**Budokan Judo Club Inc Response to the Transport for NSW
“Environmental Impact Statement (EIS) 2” dated 25th October 2012
for the North West Rail Link (NWRL) Project**

This document responds to both EIS2 (SSI 5414) and also the Request for Modification of Staged Infrastructure Approval specific to the Castle Hill Station (SSI 5645 MOD1).

Figure 6.19 Showground Station - Indicative layout

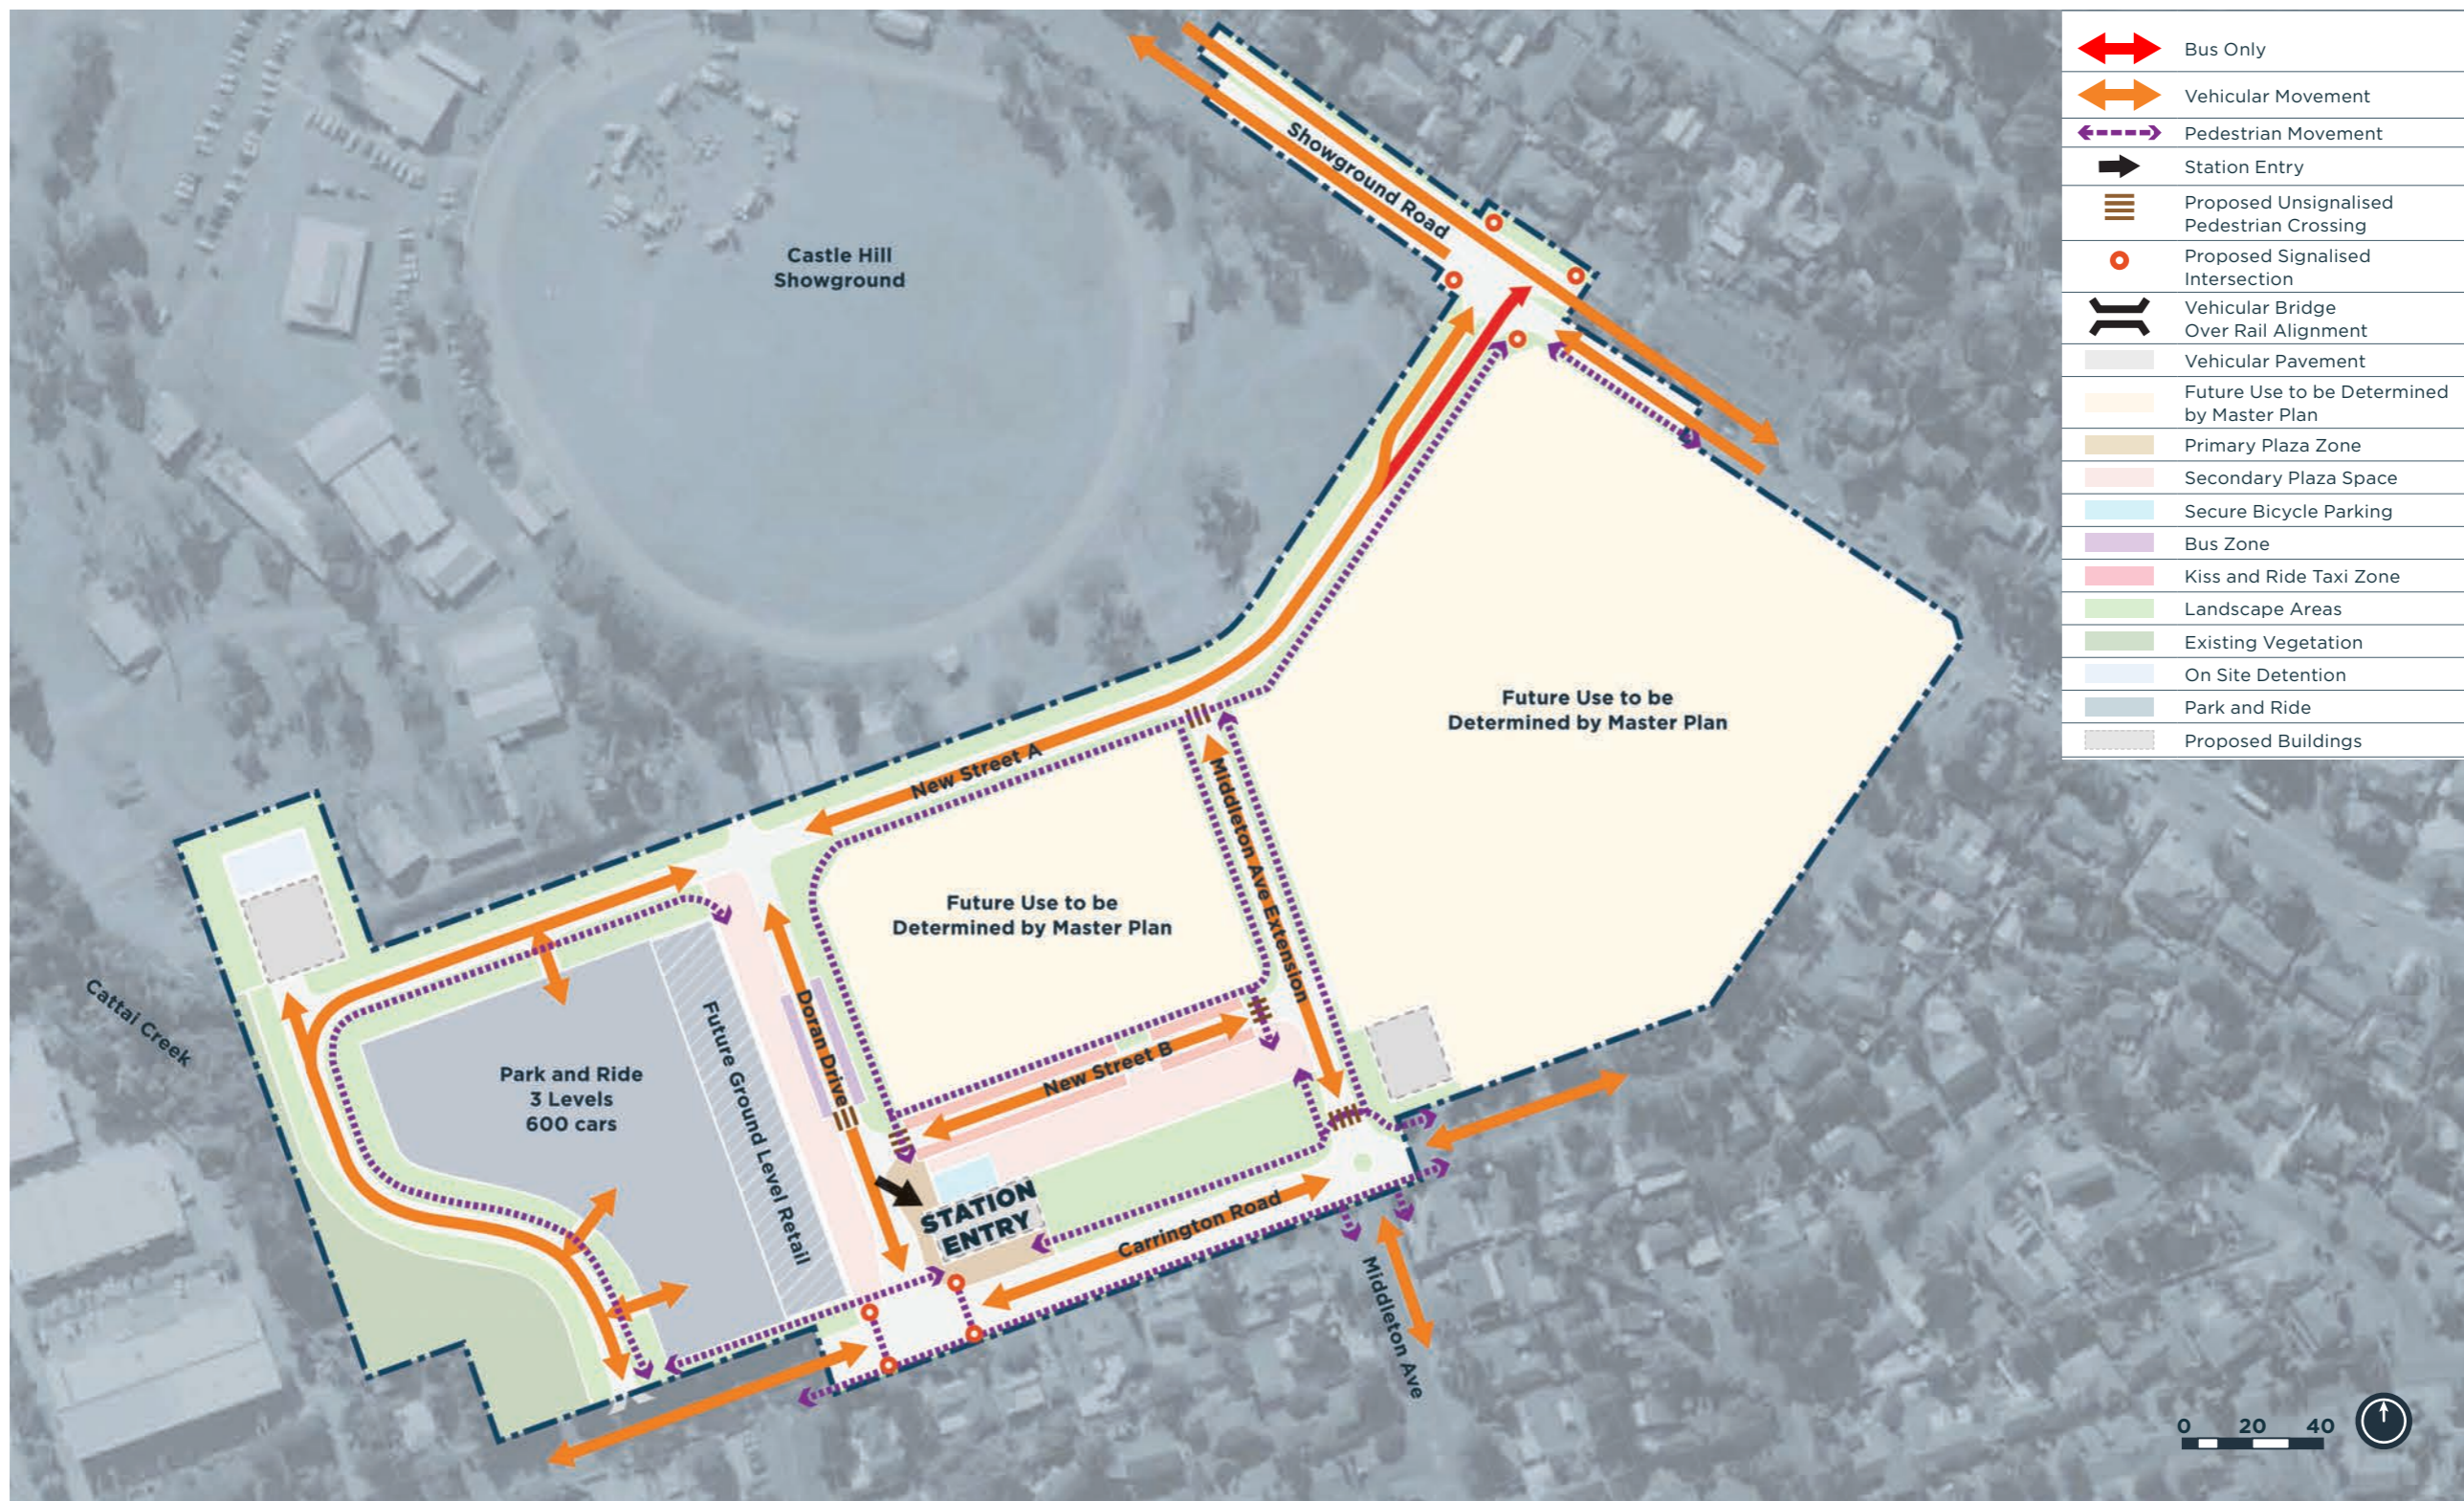
- 2) Budokan has been operating out of the Horticulture Pavilion of the Castle Hill Showground for over 15 years. The proposed Site Layout for Site 6, Showground Station in EIS2, indicates that the Horticulture Pavilion will be in close proximity to the proposed construction zone. Although now zoned on the Showground Station Precinct map as "Protected from construction impacts", risks both during and post-construction associated with the close proximity of the construction site to the Horticulture Pavilion have been identified and need to be satisfactorily managed.

Unclear from EIS2 whether construction traffic would be limited to the construction zone identified in EIS2 or whether construction traffic would be allowed to utilise the internal roads within the Showground that are outside the construction zone. Our members utilise the open space within the Showground (running) and the nearest public toilet facilities adjacent to the Showground. Our membership includes a significant number of children who would be at risk of construction traffic whilst attending and training at Budokan. Budokan seeks confirmation that Construction Traffic would be limited to the construction zone.

Unclear from EIS2 whether required parking for construction personnel would be contained within the construction zone. Given the immediate proximity of the Horticulture Pavilion (off Doran Drive) to the construction zone, there is a risk if parking is allowed outside of the construction zone, of access in terms of available parking within the Showground being restricted. The flow-on effect from inadequate parking within the Showground would be increased risk to children who may need to negotiate a congested parking situation to access for example the amenities block. Budokan seeks confirmation that parking required by construction personnel will be accommodated within the construction zone.

EIS2 identifies that Doran Drive will allow continued access to the Showground post construction. The proximity of the Horticulture Pavilion to the Showground Station precinct, upgraded Doran Drive, New Street A and the multi-storey car park will drive increased traffic flow through the internal roads of the Showground. The internal roads of the Showground and the current parking areas available within the Showground are not designed for this purpose and increased traffic flow and overflow parking would increase risk to Showground Users. Budokan seeks confirmation that (1) a traffic management plan be developed for the internal roads within the Showground that takes into account increased traffic flow in the Doran Drive / station precinct; and (2) that where upgraded roads are required within the Showground to cater for such anticipated traffic flows, such upgrades are included in the construction plan for Showground Station.
